From: David Pickford <[REDACTED]>
Sent: 19 September 2019 14:16
To: Anita Gardner <[REDACTED]>
Subject: FW: 22 Beach Road, Littlehampton.

Subject: 22 Beach Road, Littlehampton.
Importance: High

Figure 4. Internal Measurement Positions

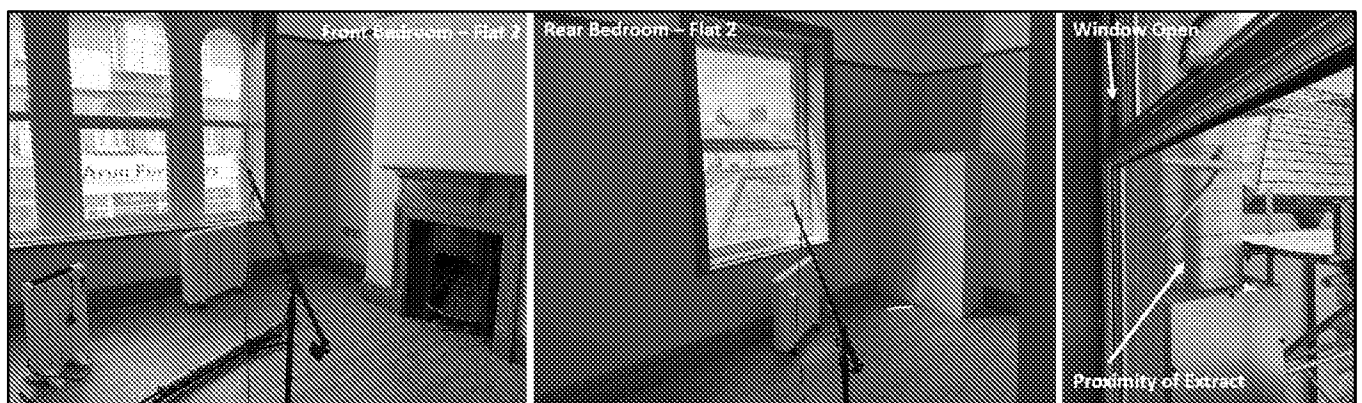
The reverberation times were measured in each of the locations where the surveys were undertaken. As noted from Table 3 in the report, the front bedroom in flat 2, was considerably higher in terms of reverberation than the smaller two bedrooms measured. As per Figure 4 of the report, the image displayed on the left hand side shows the laminated floor already laid.

Figure 7. Review of 1-hour periods inside Flat 1 bedroom

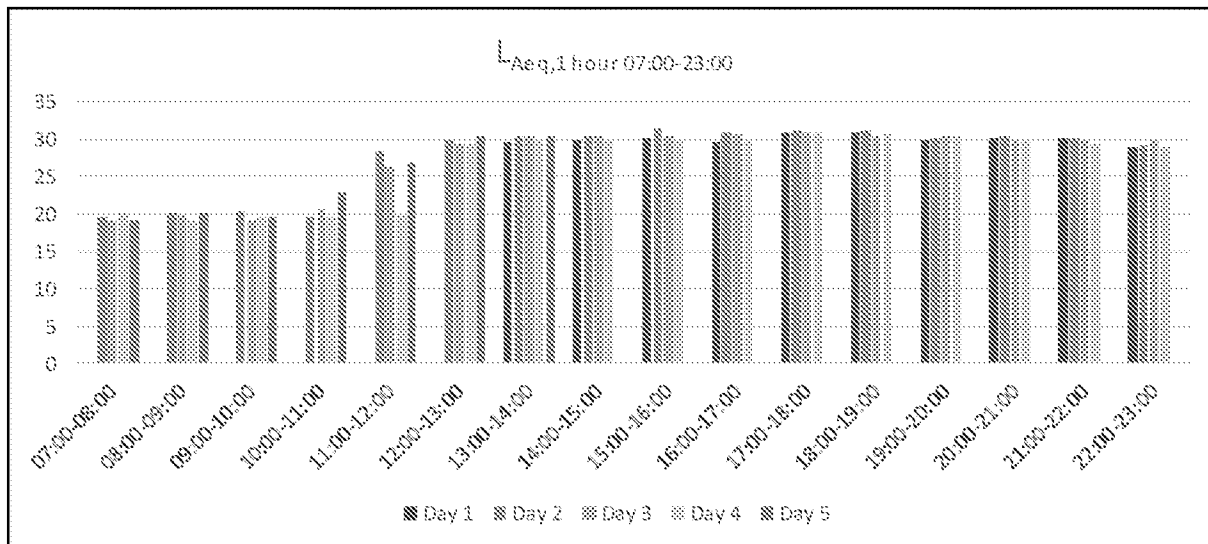
In respect of your report, 23rd August, page 3, paragraph 3 then to clarify, my comment related to **Figs 6 & 7** and **Flat 1** where daytime noise was found to be 28.8 with windows closed and therefore 39 to 44dB with reasonable adjustment for an open window.

Figures 6 and 7 in the report relate to Flat 1, however the references to 39 and 44dB relate to Flat 2, front bedroom, which is reported in Figure 10.
